About the application

Application number: 2026/91763	
What is the application for?:	Erection of 40 residential dwellings and associated works
Address of the site or building:	Land off Barnsley Road, Denby Dale, Huddersfield,
Postcode:	LS23 7BA

Dwg No.	Scale	Date	Chg	Rev
E25/8361/001_01B	1/500 @A1	OCT'2025	MH	JM

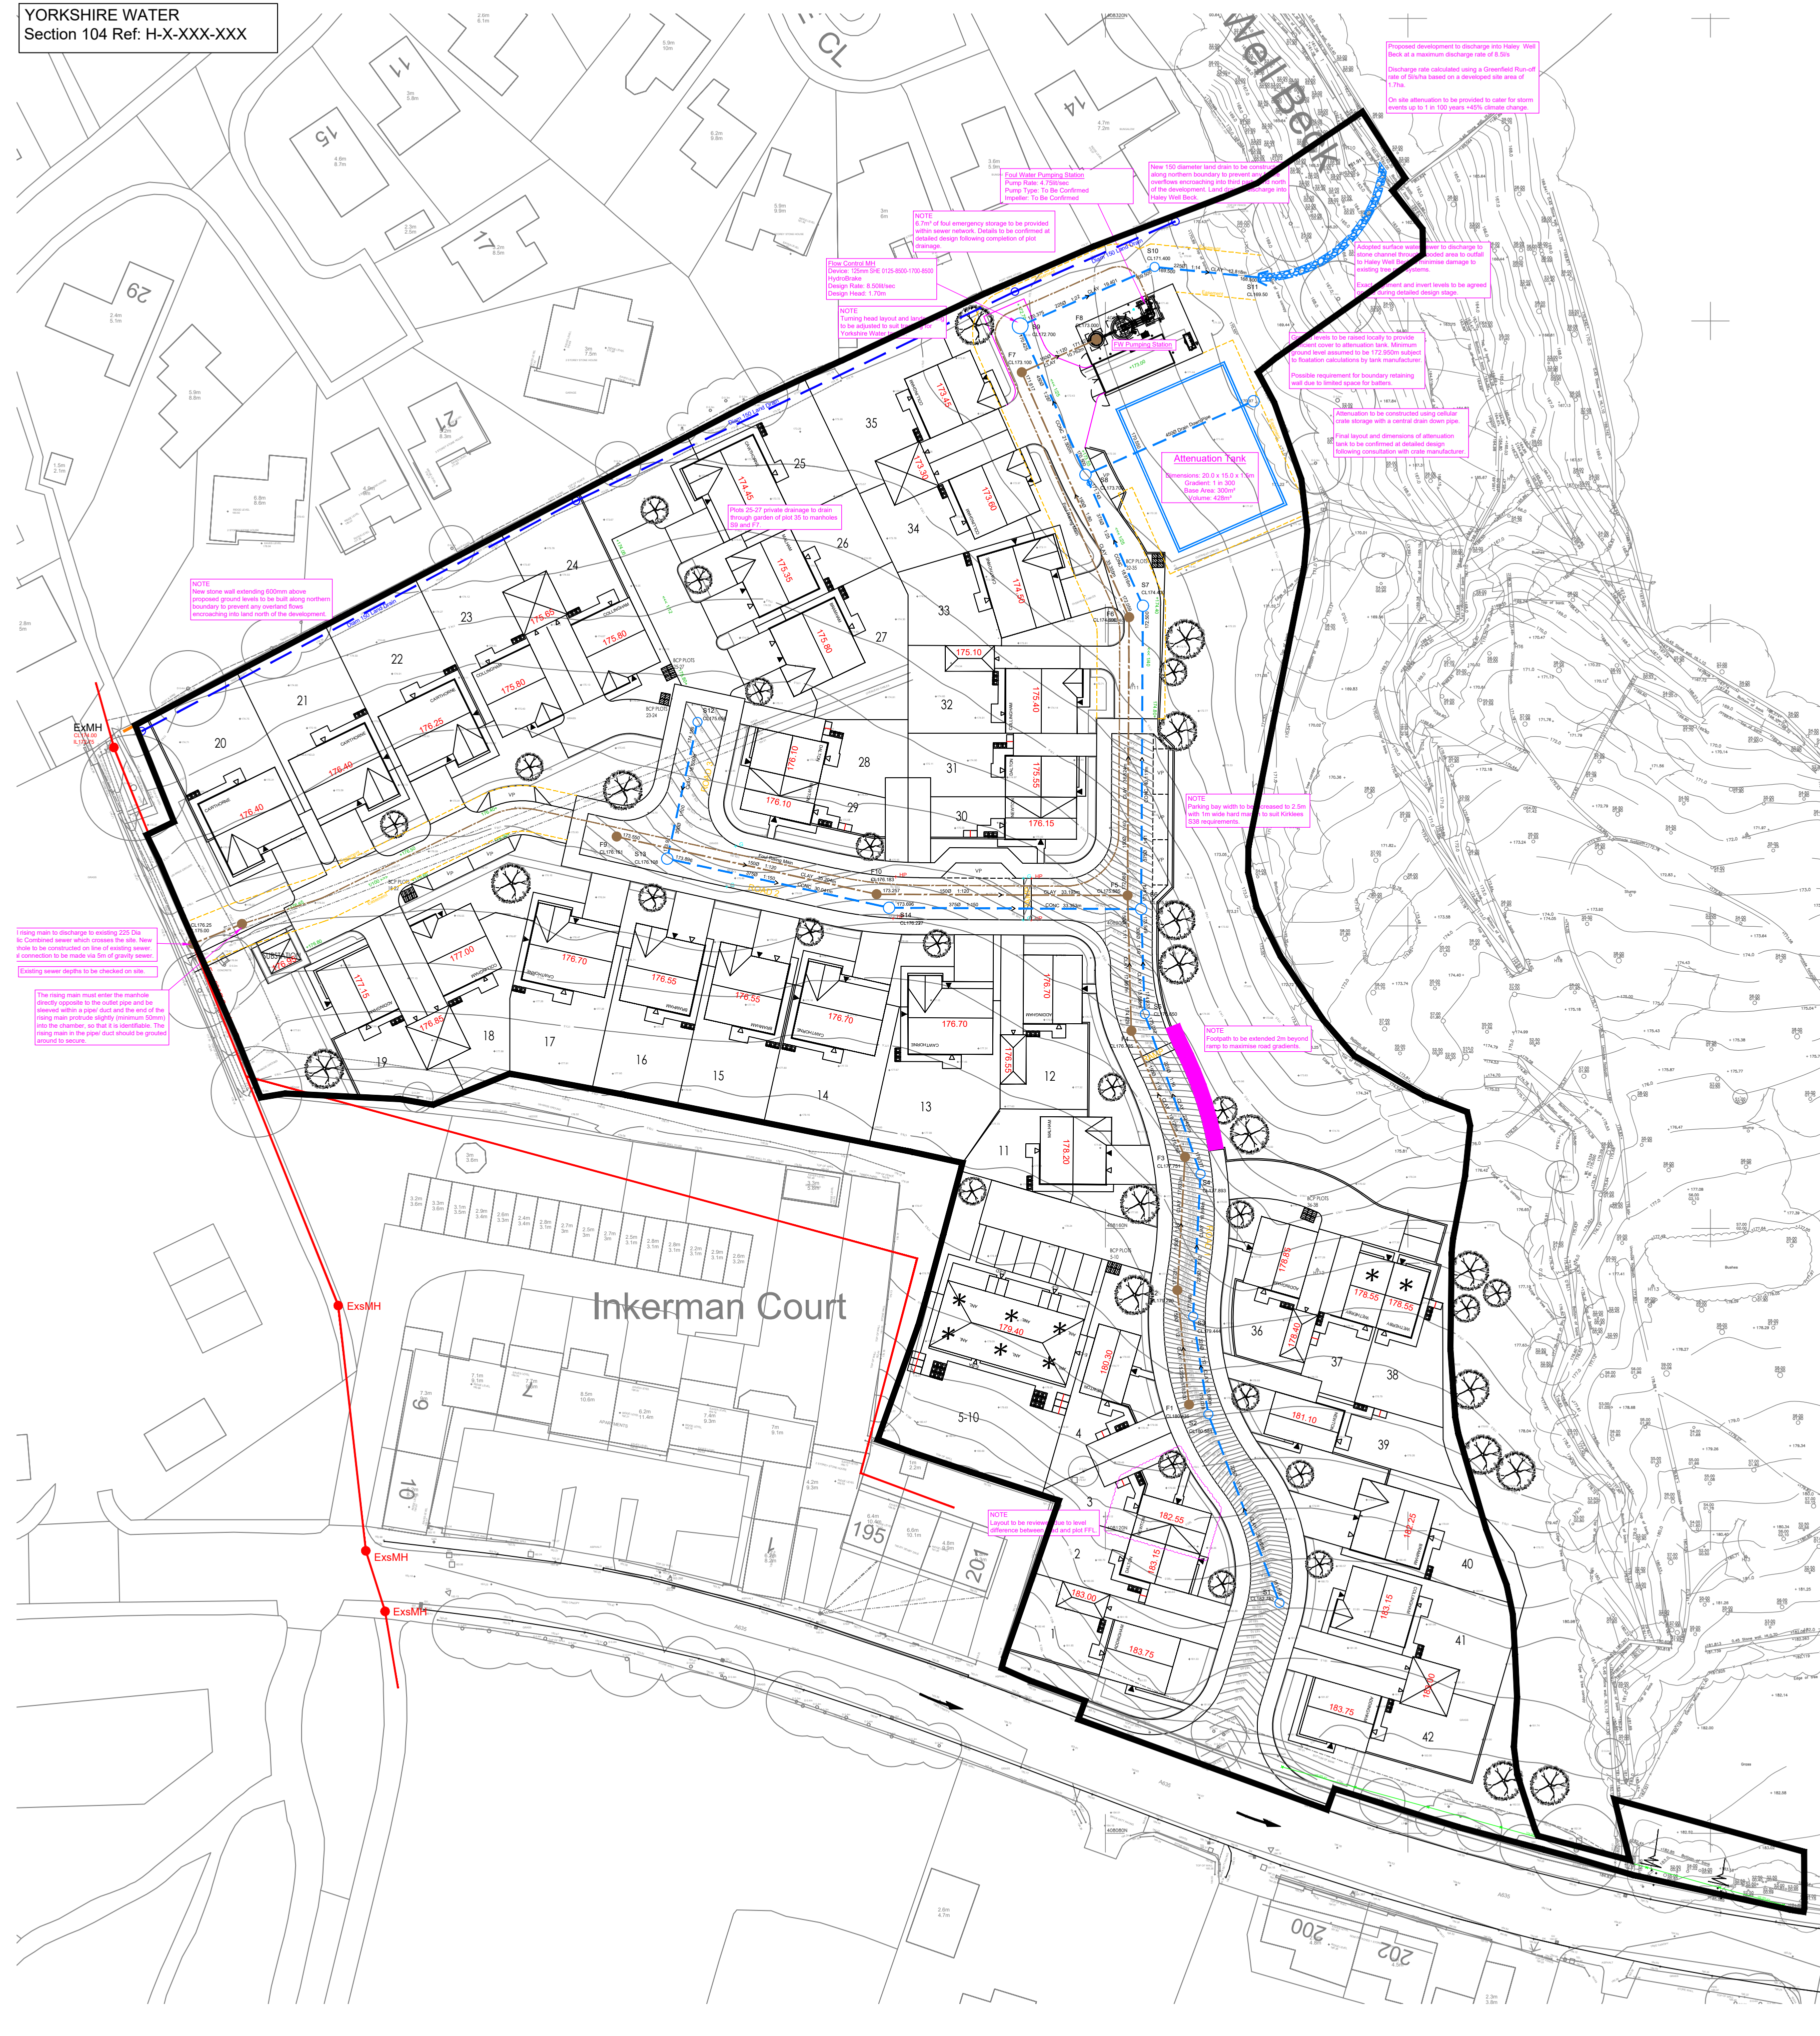
Type of comment: An objection	
Do you wish your comments to be published on the website anonymously?	Yes
Although I sent a query (both online and by 1st class post) on behalf of the majority of the people currently residing on the northern boundary of the proposed development some 11 days ago, we have received no response, nor have the comments been posted on the application webpage. On the basis that the land drainage measures are, at best, ambiguous, I wish to object to the plans as the compaction of earth will exacerbate flooding to properties on the northern boundary.
